25 March 2026

17 Evelyn Avenue,
Rustington,
West Sussex BN16 2EJ.

PLANNING APPLICATION R/31/26/HH: 15 EVELYN AVENUE BN16 2EJ

Proposed Roof Plan
1:200 @ A3

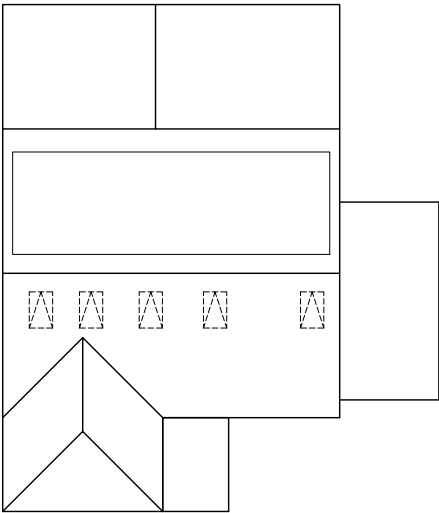
"A modest enlargement to the approved dormer" is not a justifiable characterisation. It is virtually the full width of the bungalow, which is almost 9 metres, rather than protruding at the mid-point of the pitched roof and it is double the width of the permitted development. This seems contrary to guidance in the Arun District Design Guidance that dormers should be "a minor incident in the roof plane".

The LDC dormer is only about half the width of the proposed dormer, being subject to permitted development limits. If this is substantial, the one to replace it would be massive.

See above comments on the increase in size of the dormer. Also the LDC dormer has only one, central window, overlooking much less than the two windows towards the ends of the dormer.

“The suggestion that the proposal would fundamentally disrupt the street scene does not properly account for the lawful fallback position, which would result in a very similar visual outcome.” This simply highlights the fact that the character of the street was not properly considered in relation to the permitted development. But the five rooflights make this even worse.

It should be self-evident that this use of cladding would be completely out of character with the properties in Evelyn Avenue. And the cladding at the sides of the proposed development would be visible from the street as well as the cladding on the front. Also, the cladding of the full width rear dormer would make it even more intrusive.

Rev	Notes	Date
 M: 07599199759 E: info@nat-design.co.uk www.nat-design.co.uk		
Project:		
15 Evelyn Avenue Rustington BN16 2EJ		
Drawing:		
Proposed Elevations		
Drawn by NSE		Scale as shown
Date Feb 2026		Revision
Drawing		
2027 - DPA - 06

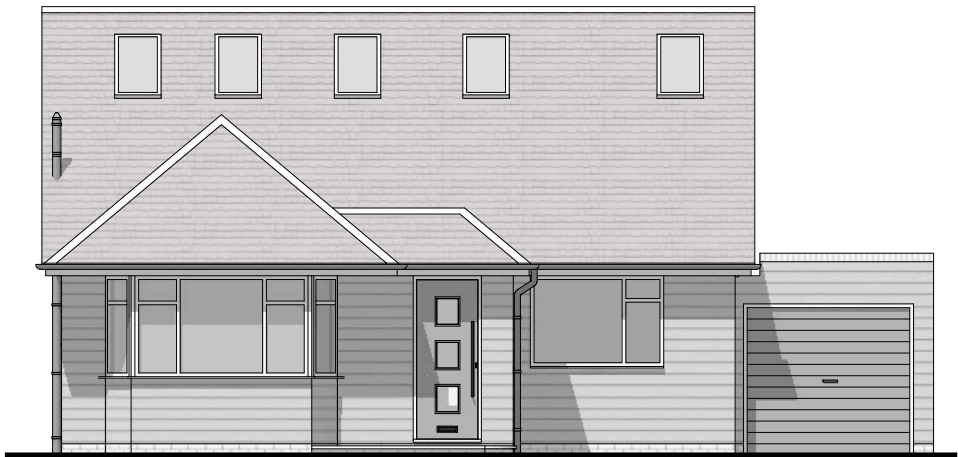
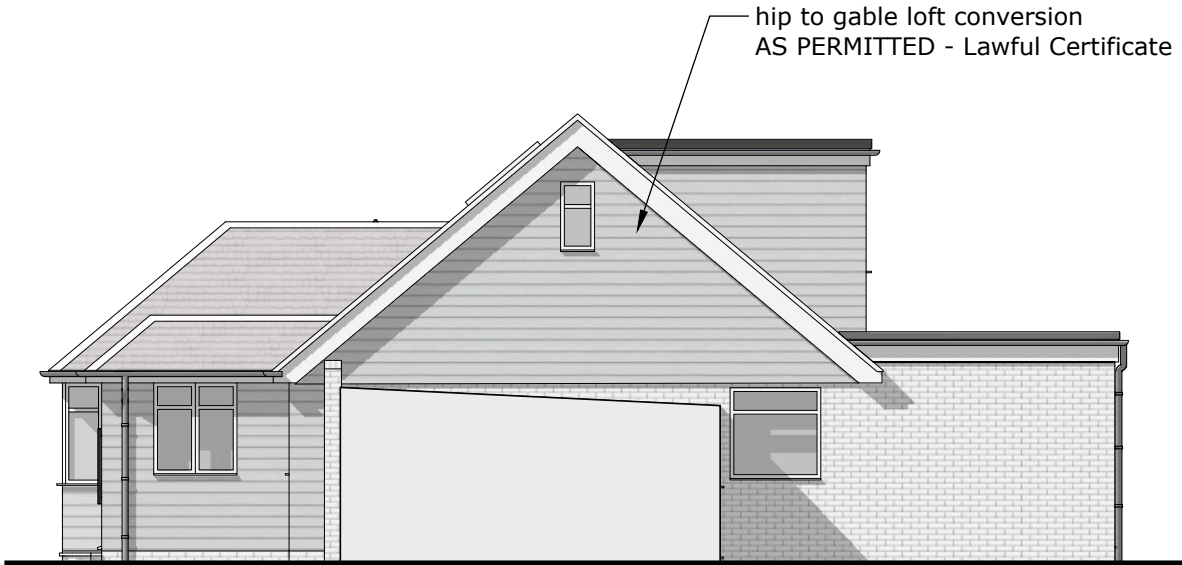
As explained above, this is more than “a minor variation”. The new dormer is virtually the full width of the bungalow (nearly nine metres), about twice the width of the permitted development. This is not “a simple and unobtrusive form which does not overpower the existing or neighbouring properties” in accordance with the Arun District Design Guide.

Furthermore, No 15 sits in the middle of a row of eleven identically built bungalows that are architecturally uniform and do not have cladding. Indeed, the LDC was amended at Arun DC’s instigation to exclude the introduction of cladding, though this is not shown on the plan with this application.
